LEWIS-PALMER SCHOOL DISTRICT No. 38 FILING NO. 1

A SUBDIVISION OF A PORTION OF THE SOUTH 1/2 OF SECTION 27, RANGE 67 WEST OF THE SIXTH PRINCIPAL MERIDIAN, COUNTY OF EL PASO, STATE OF COLORADO

AUGUST 31, 2022 Sheet 1 of 1

# LEWIS-PALMER SCHOOL DISTRICT No. 38 FILING NO. 1

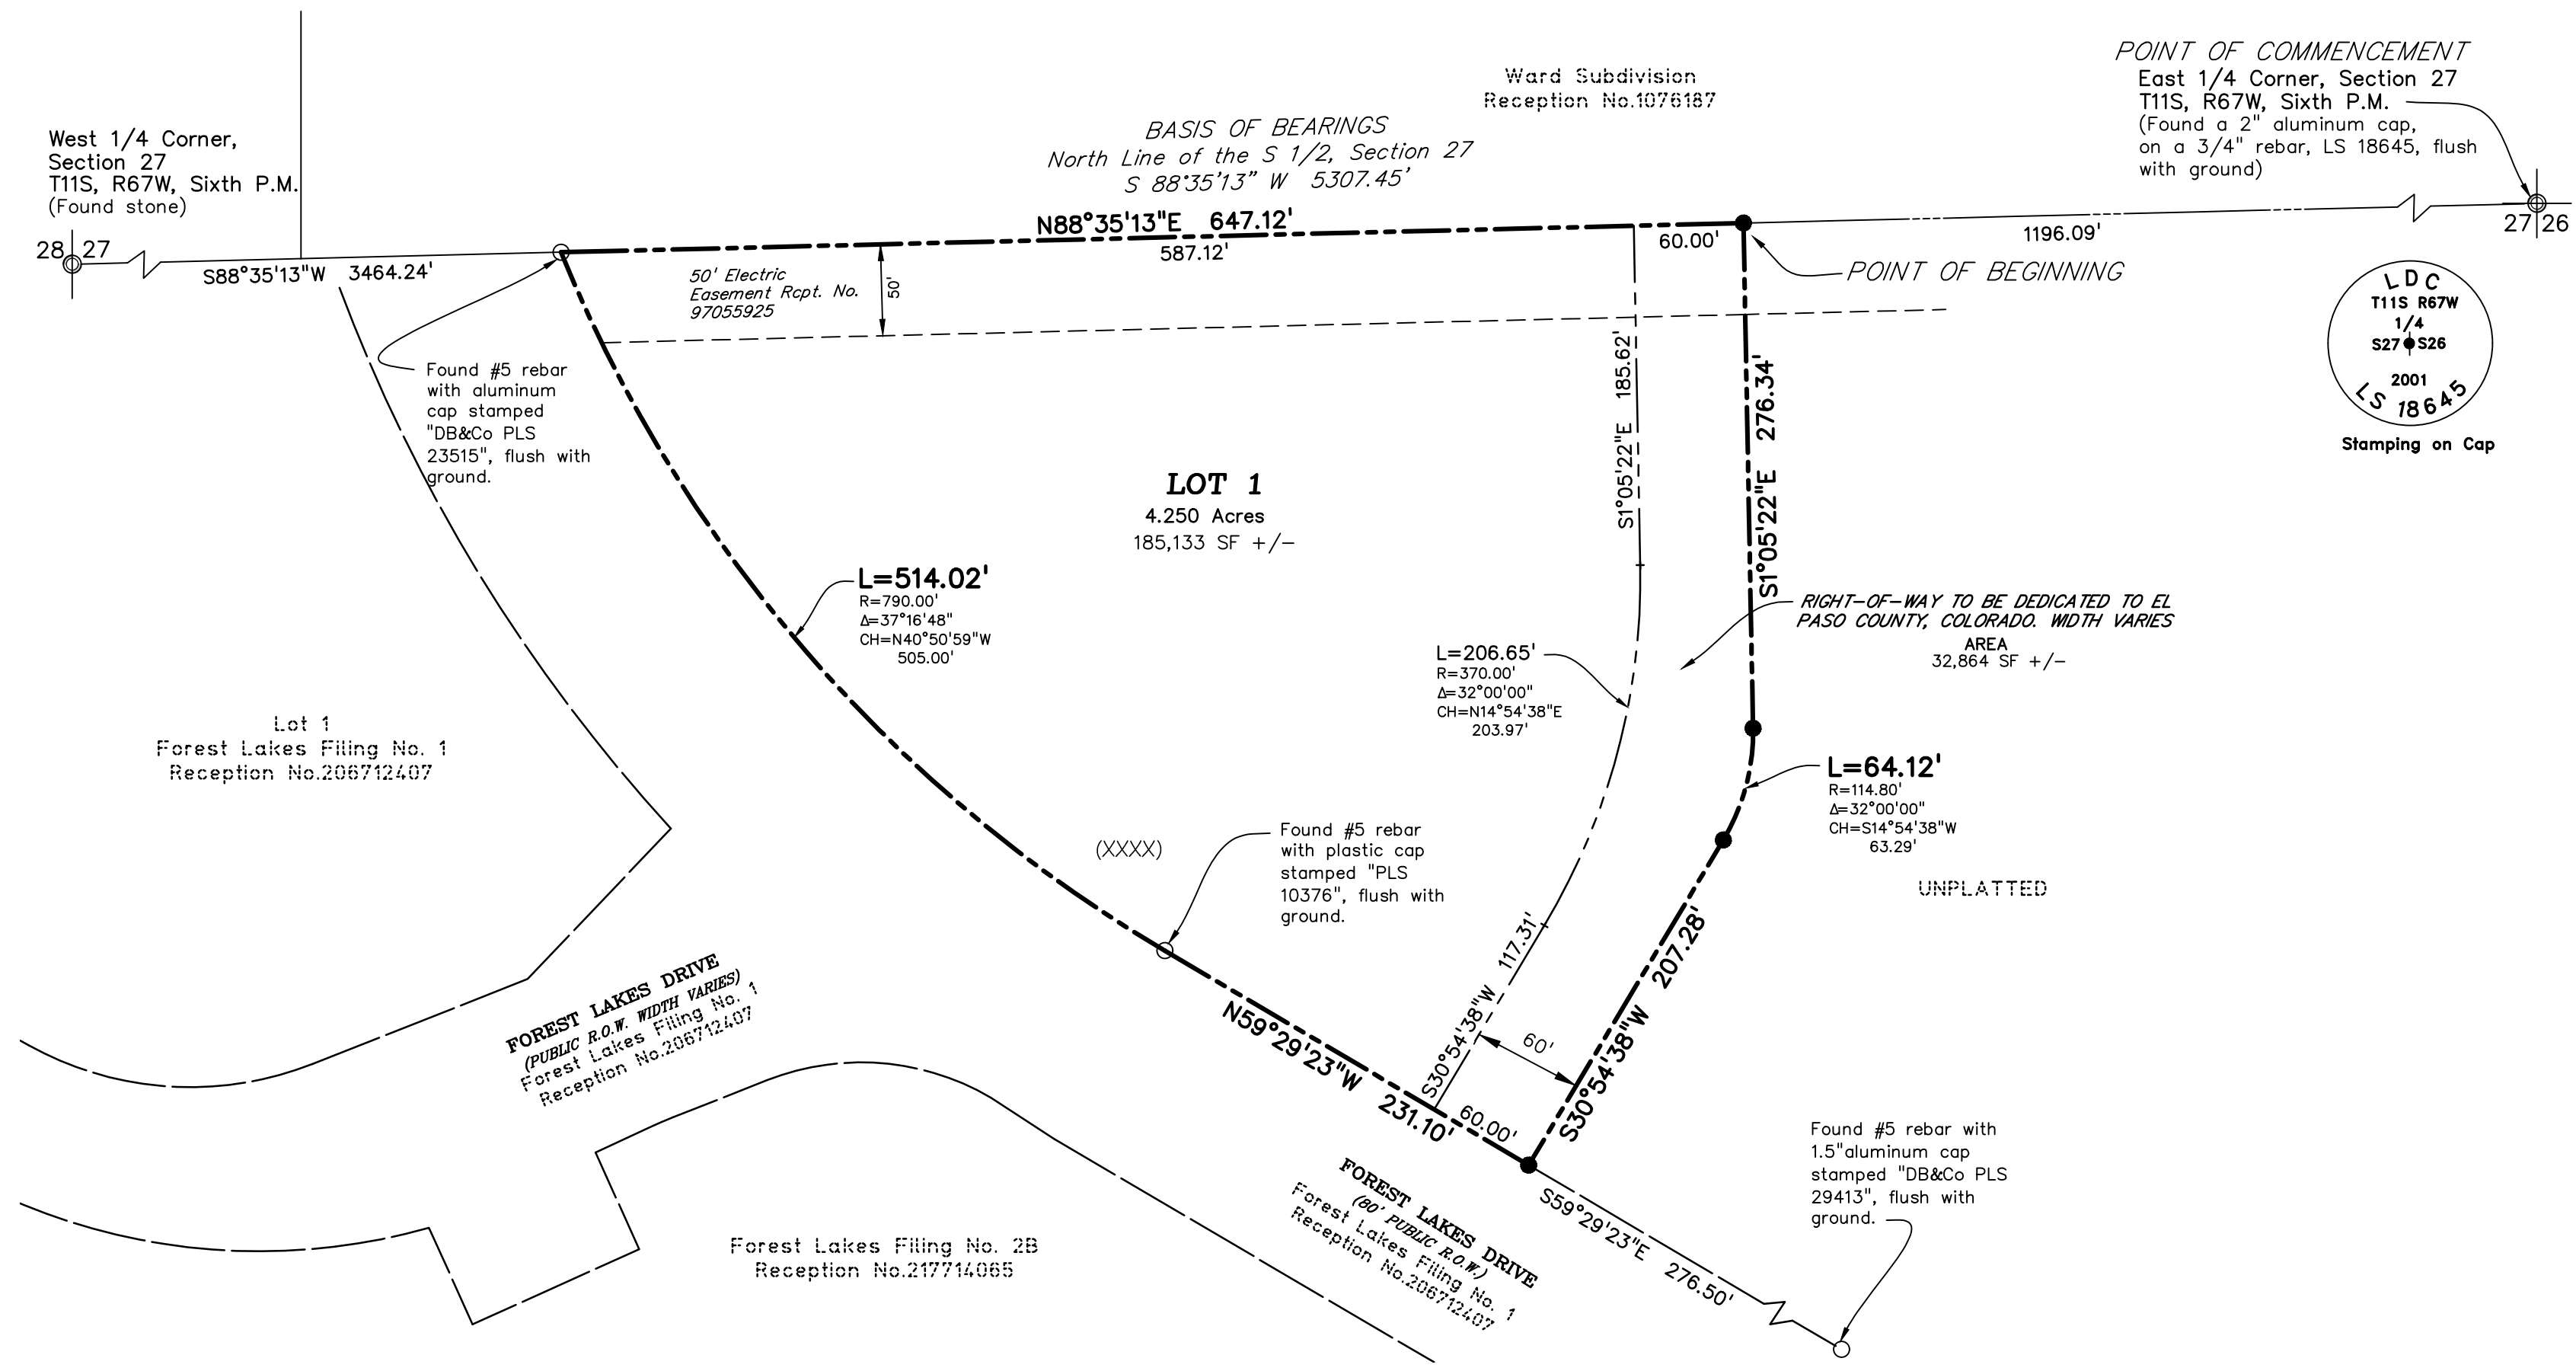
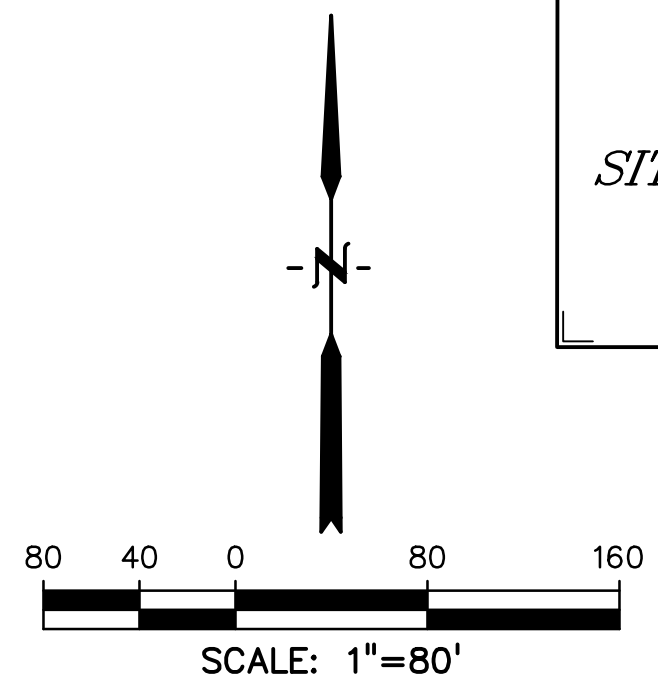
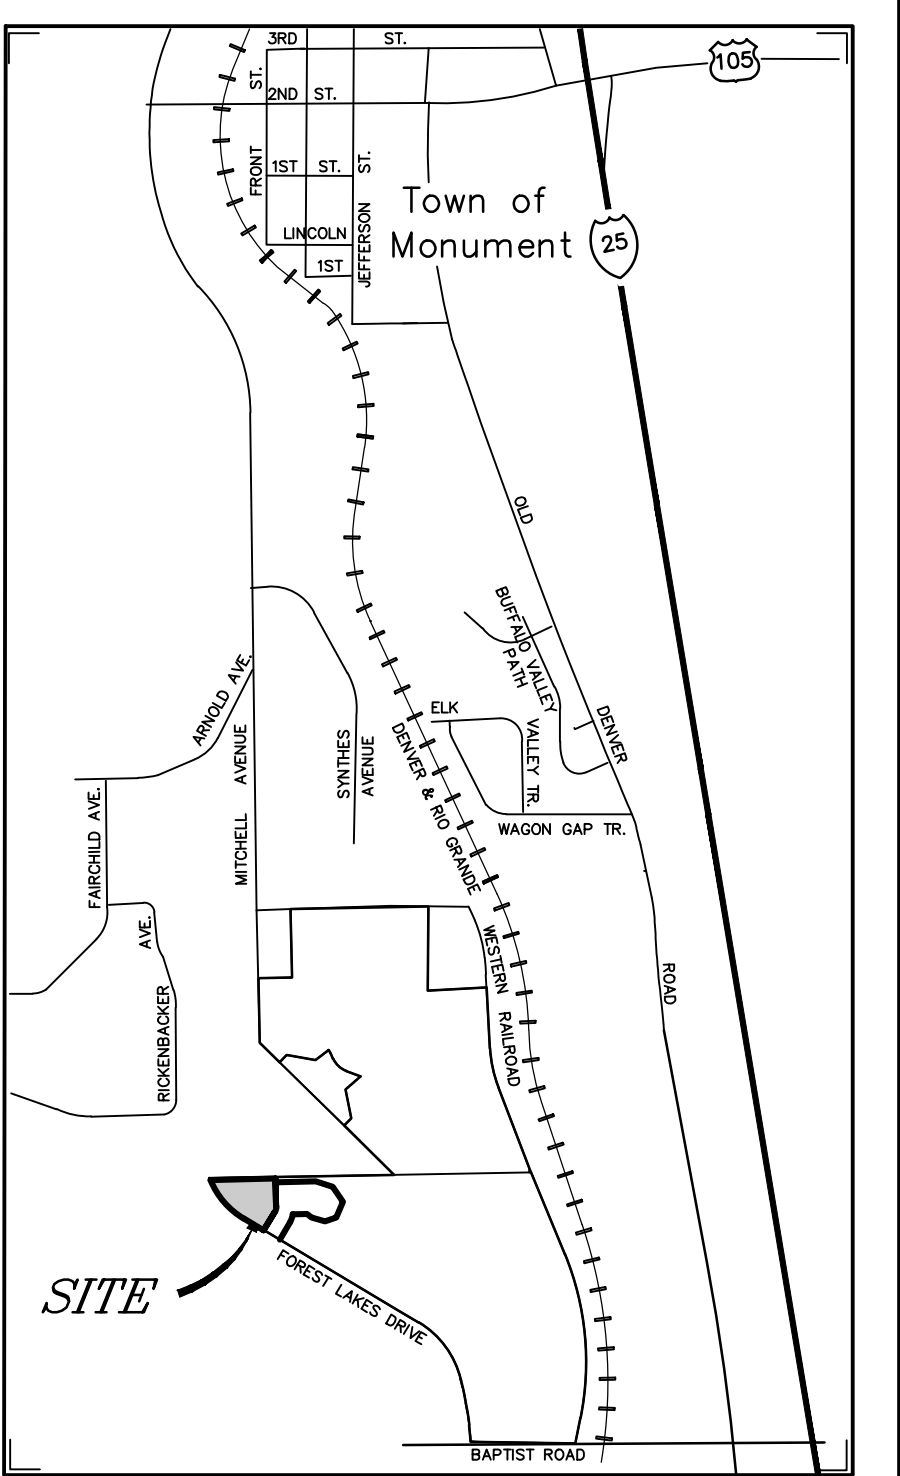
Add the following notes:

- The final total gross acreage, gross density, net density and net acreage of the subdivision
- The net acreage of land to be dedicated

Add Plat Note-Access: No driveway shall be established unless an access permit has been granted by El Paso County.

Certification sufficient as written. Requested verbiage is not in conformance with current state of Colorado standards.

ACREAGES ADDED. DENSITY DOESN'T BELONG ON A PLAT.

NOTE ADDED
